Longfield Solar Farm

Statement of Common Ground – Essex County Council, Braintree District Council and Chelmsford City Council (the Host Authorities)

PINS Reference: EN010118

Document Reference: EN010118/EX/8.4(E)

Figure 1. Location and proposed land take

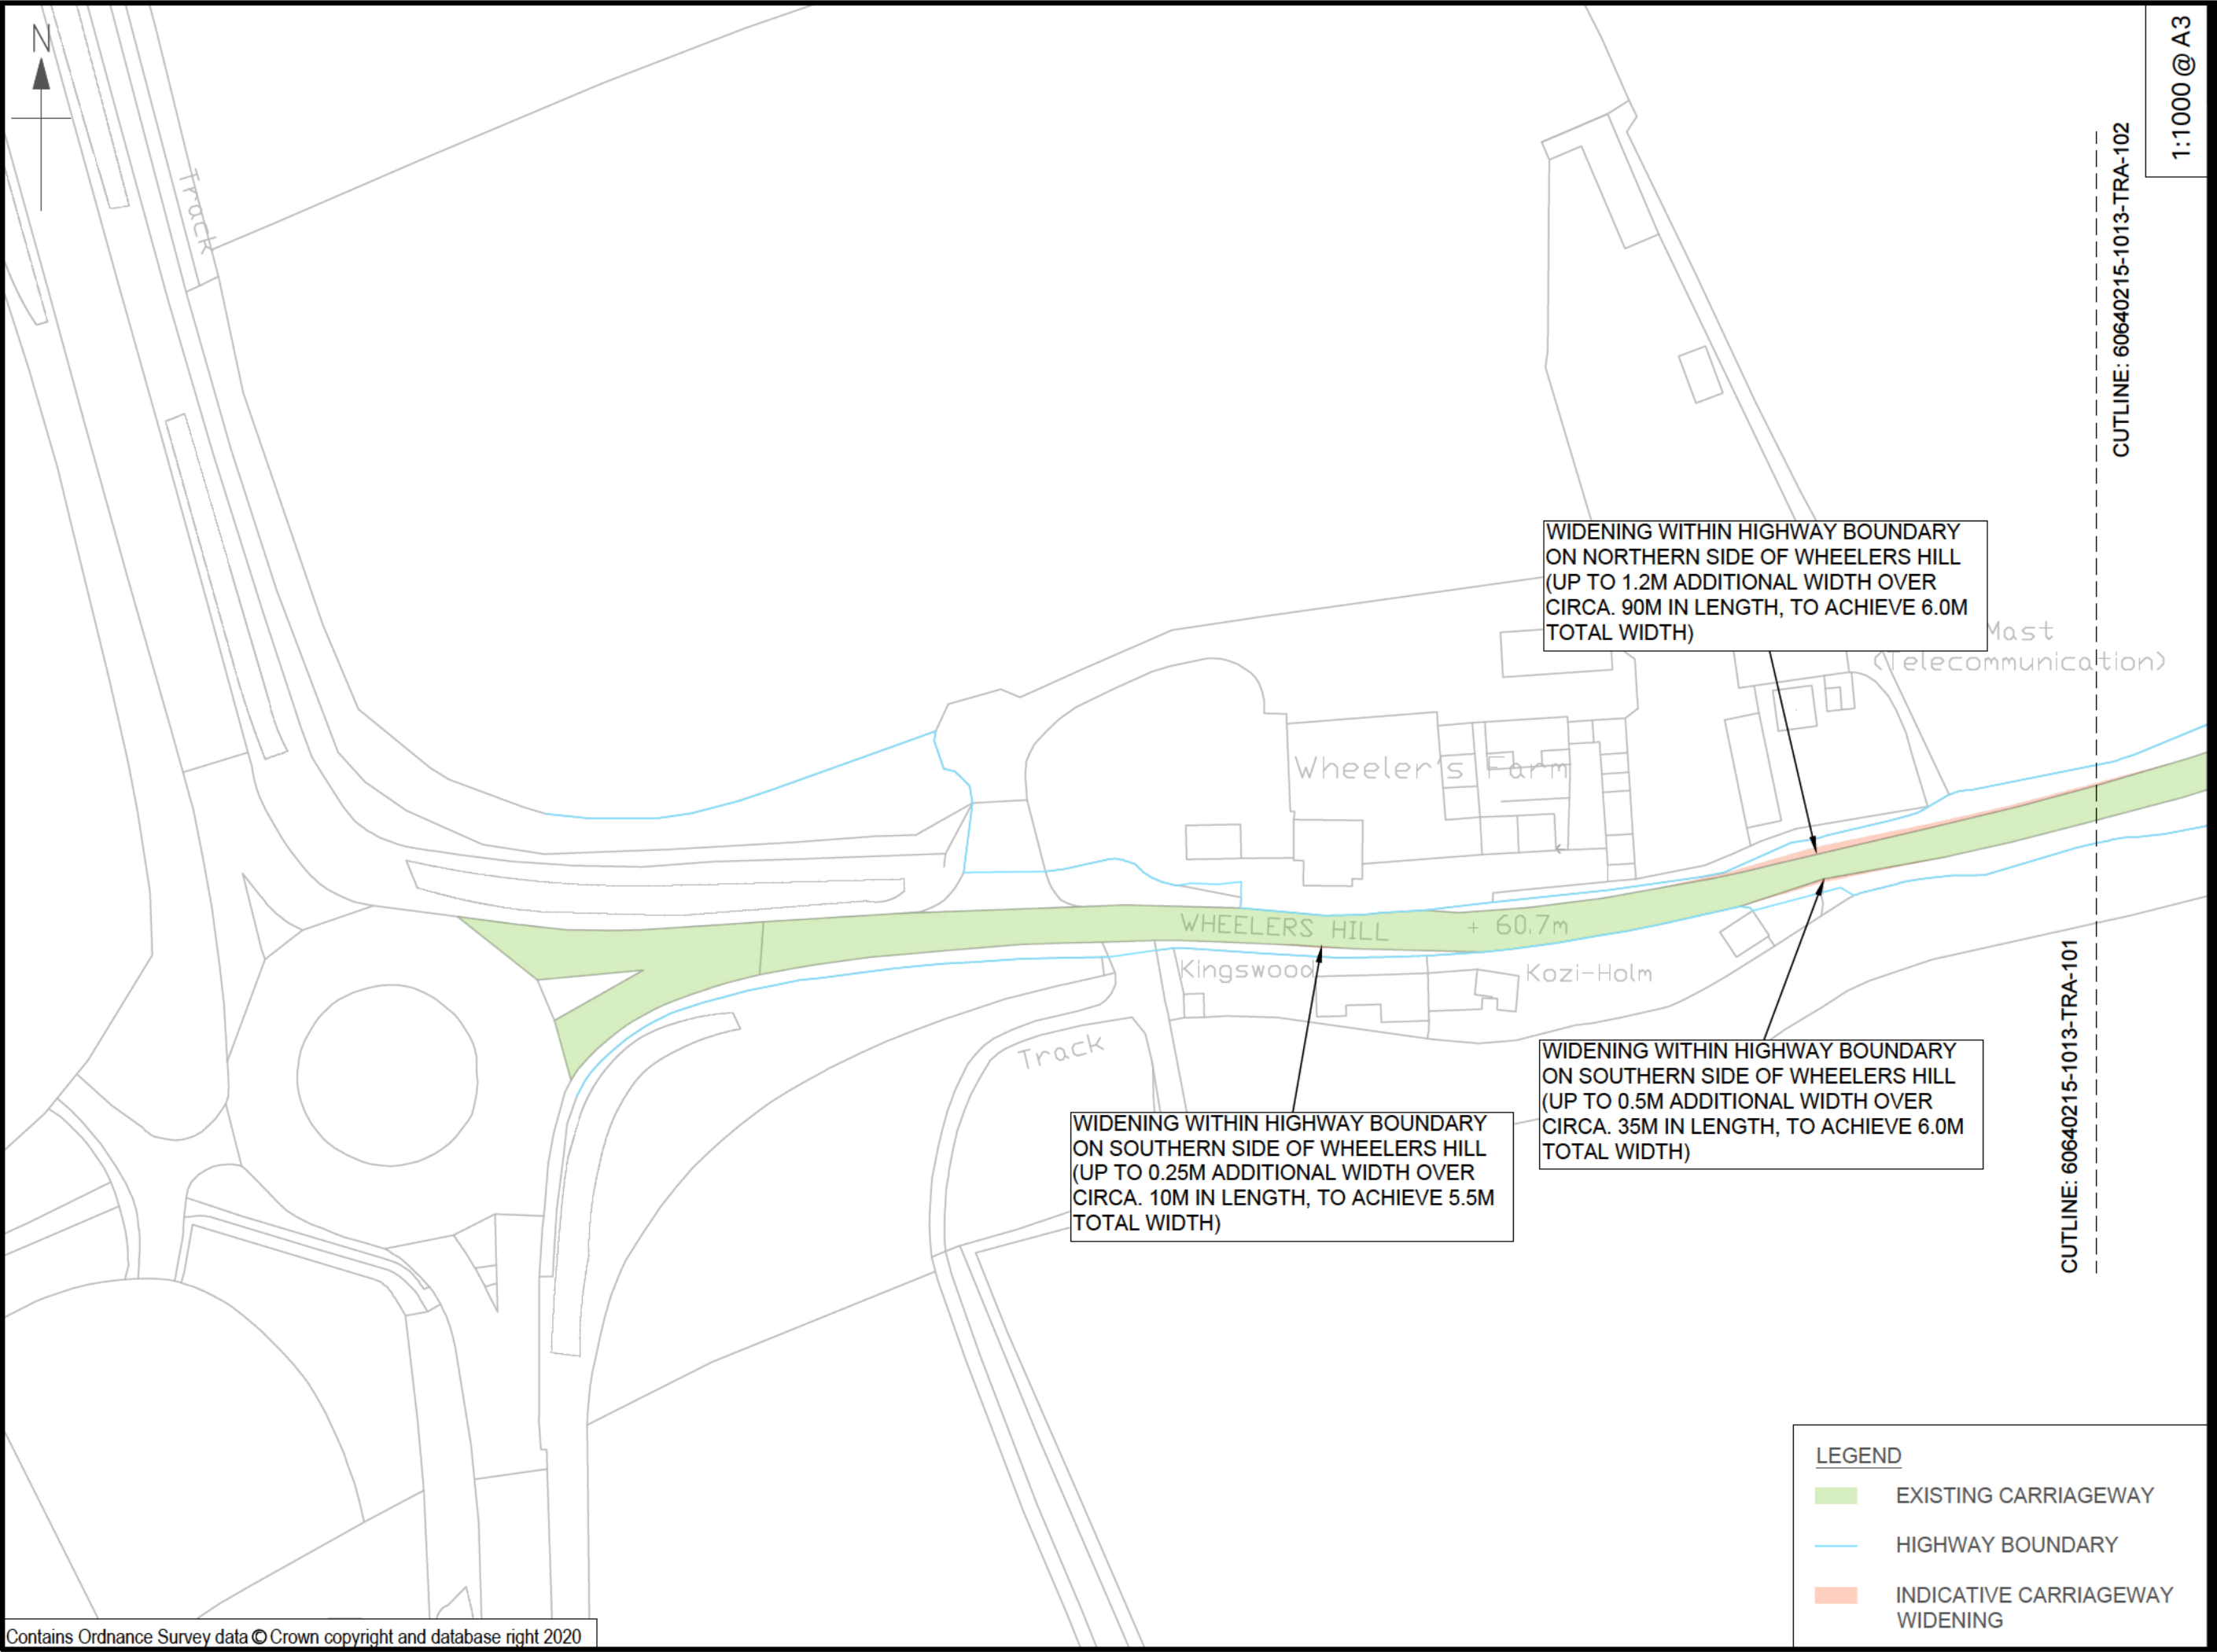
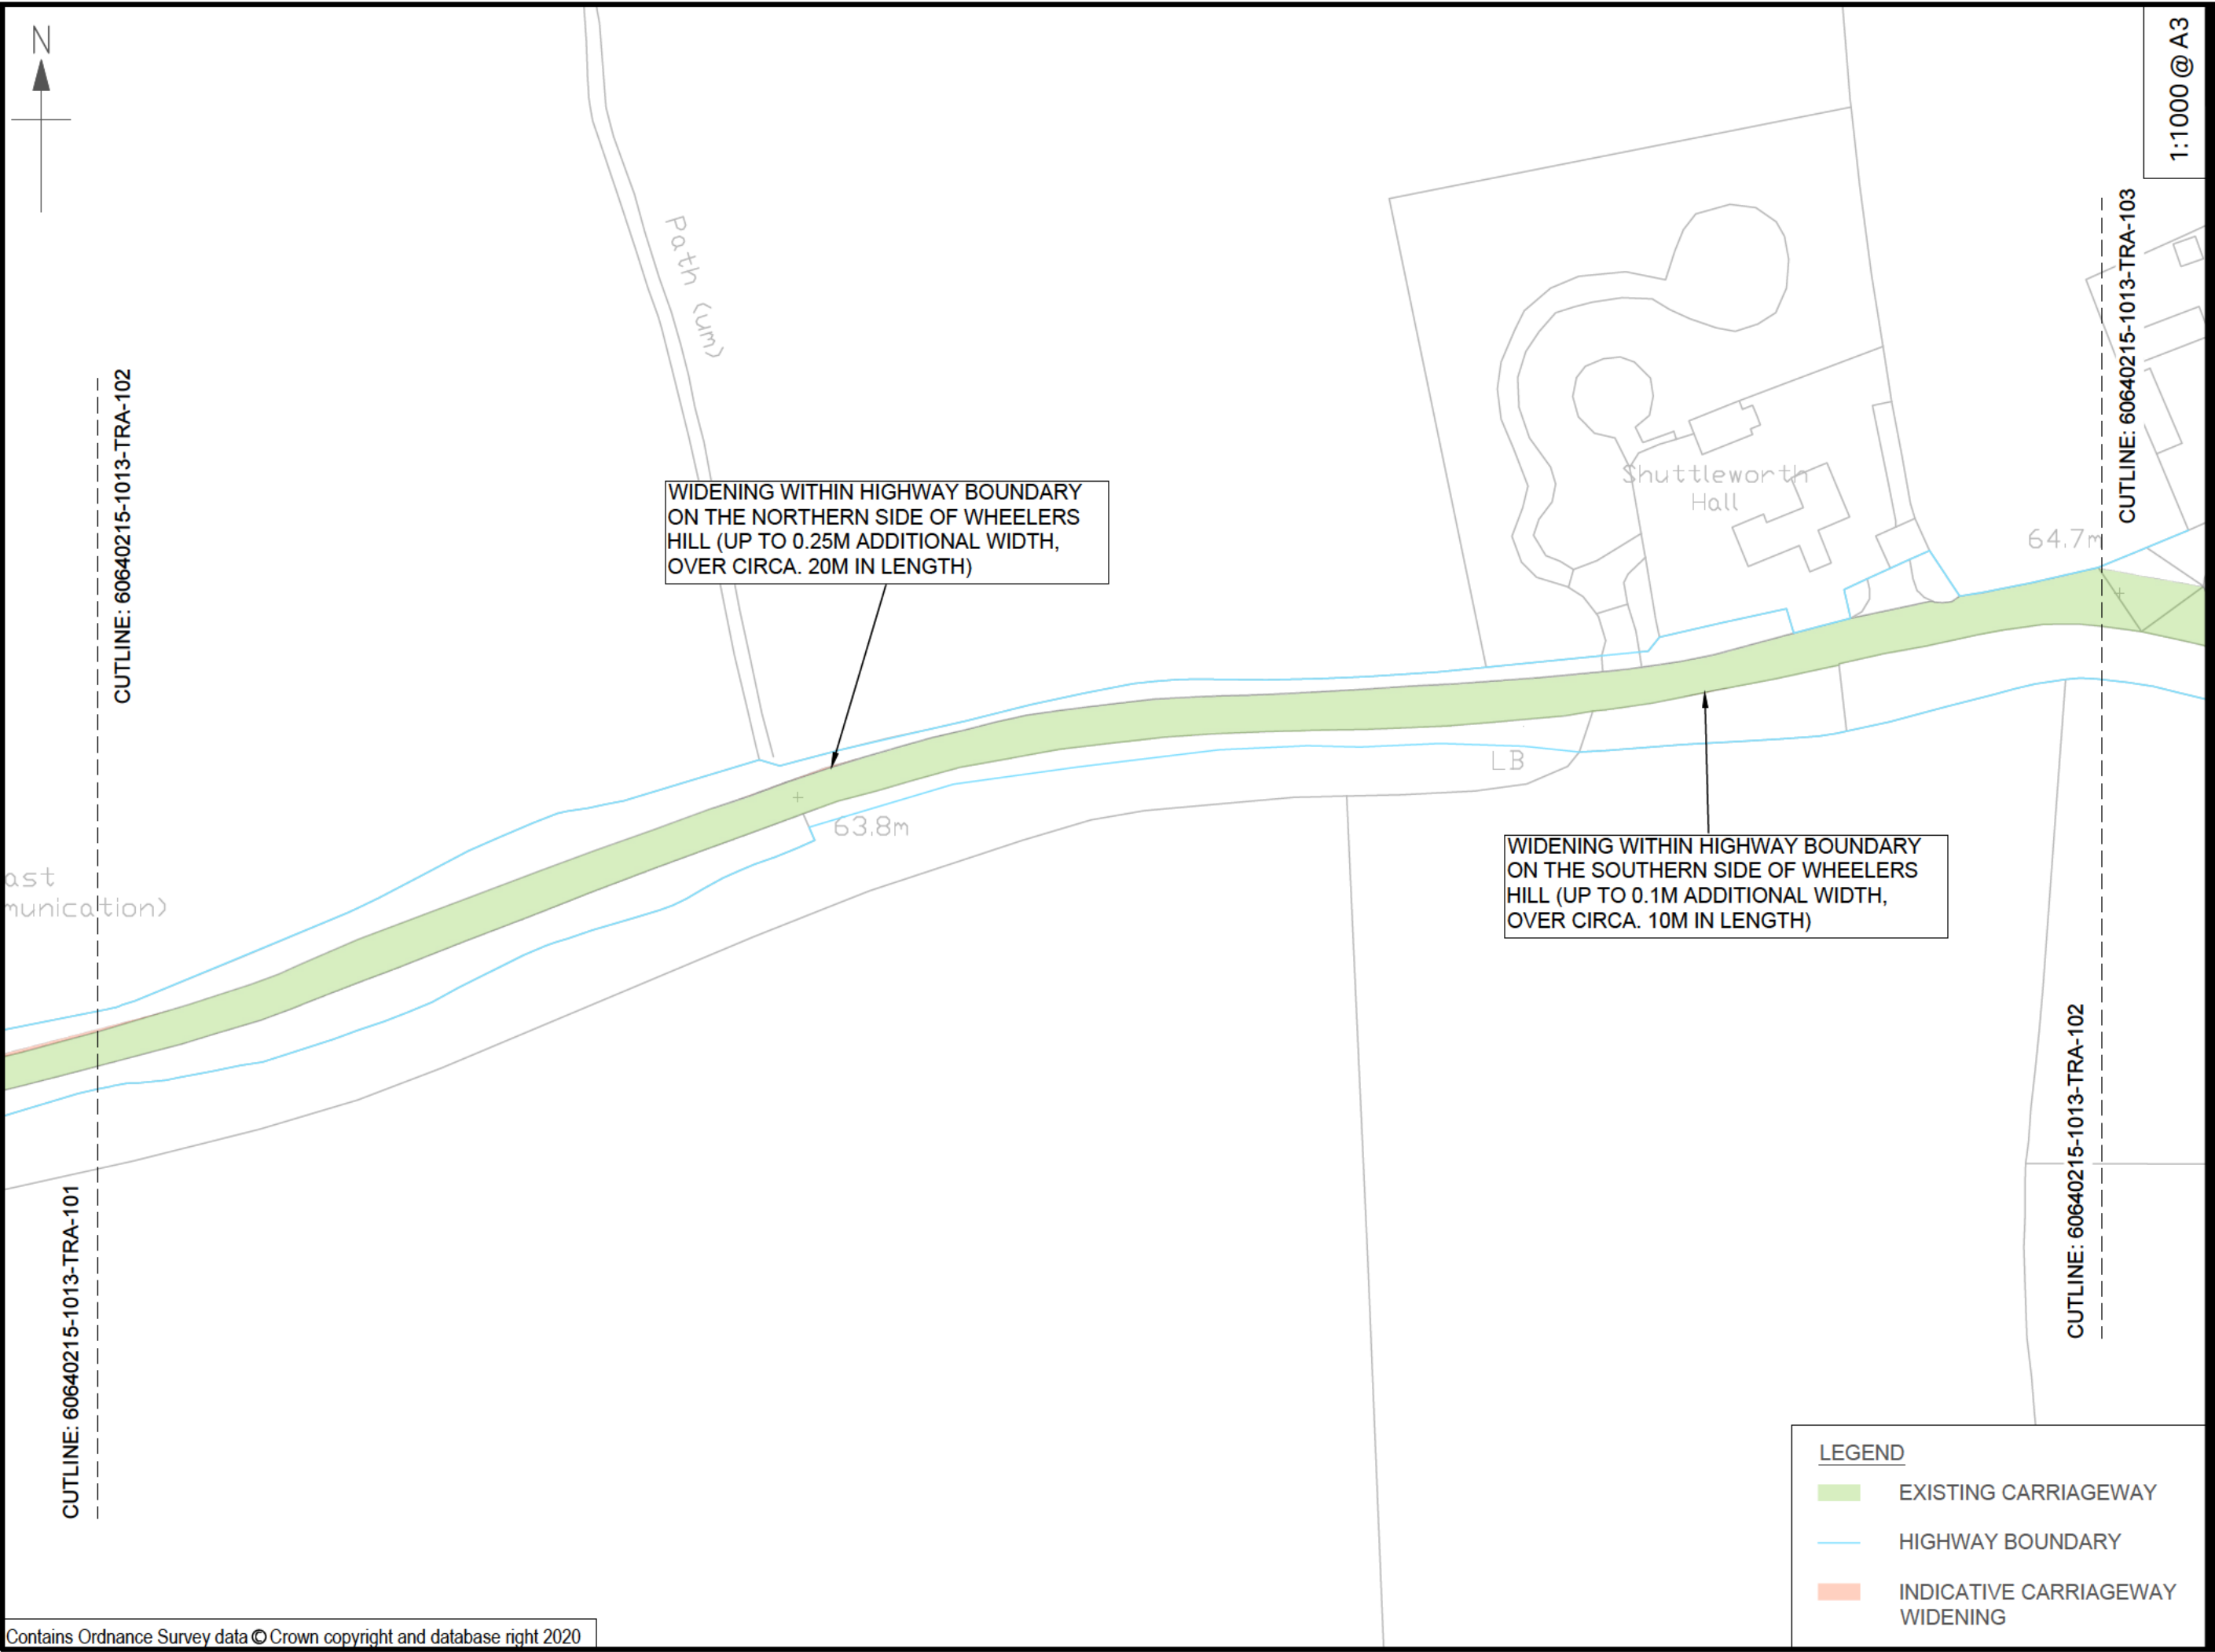
Ref	Sub-topic	BDC's Position	CCC's Position	ECC's Position	Applicant's Response	Status
		<ul style="list-style-type: none"> Proposed carriageway widening on Wheelers Hill, Cranham Road and Waltham Road. Noakes Farm crossing point Locations where permissive routes join or cross existing highway. 			<p>with ECC Highways for review on 12th July 2022. Following this, the only outstanding action was to undertake a RRRAP assessment to determine whether safety fencing/ barriers are required on Waltham Road as a result of Longfield Solar Farm which can be accommodated within the highway or land within the control of the Applicant. The RRRAP assessment was carried out in October 2022 and the Designer's Response was updated to reflect the findings/ recommendations. The updated Designer's Response and RRRAP was shared with ECC Highways on 1st November 2022.</p> <p>The remaining points picked up with the Stage 1 RSA have been addressed as part of the Designer's Response and as such no further actions are considered to be required following the completion of</p>

Ref	Sub-topic	BDC's Position	CCC's Position	ECC's Position	Applicant's Response	Status
TRA-05B	Condition Survey	ECC: ECC considers that despite the widening to 6 metres, where possible there remains the possibility that additional traffic could impact on the condition of the highway asset and verges adjacent to the highway. The Construction Traffic Management Plan should include reference to before and after studies for any vulnerable sections of the highway asset being required together with a programme for reinstatement of any defects both during and after the construction period.			A condition survey will be carried out on Wheelers Hill, Cranham Road and Waltham Road (125m section between Cranham Road and the proposed site access) pre-construction, during construction and post-construction, to identify any defects that arise to highways assets/ verges during the construction phase of the Scheme for re-instatement. This will be secured within the Framework CTMP which has been updated and resubmitted accordingly.	ECC: Agreed following the meeting on 26 th September 2022 and on the basis that the Framework CTMP has been updated.
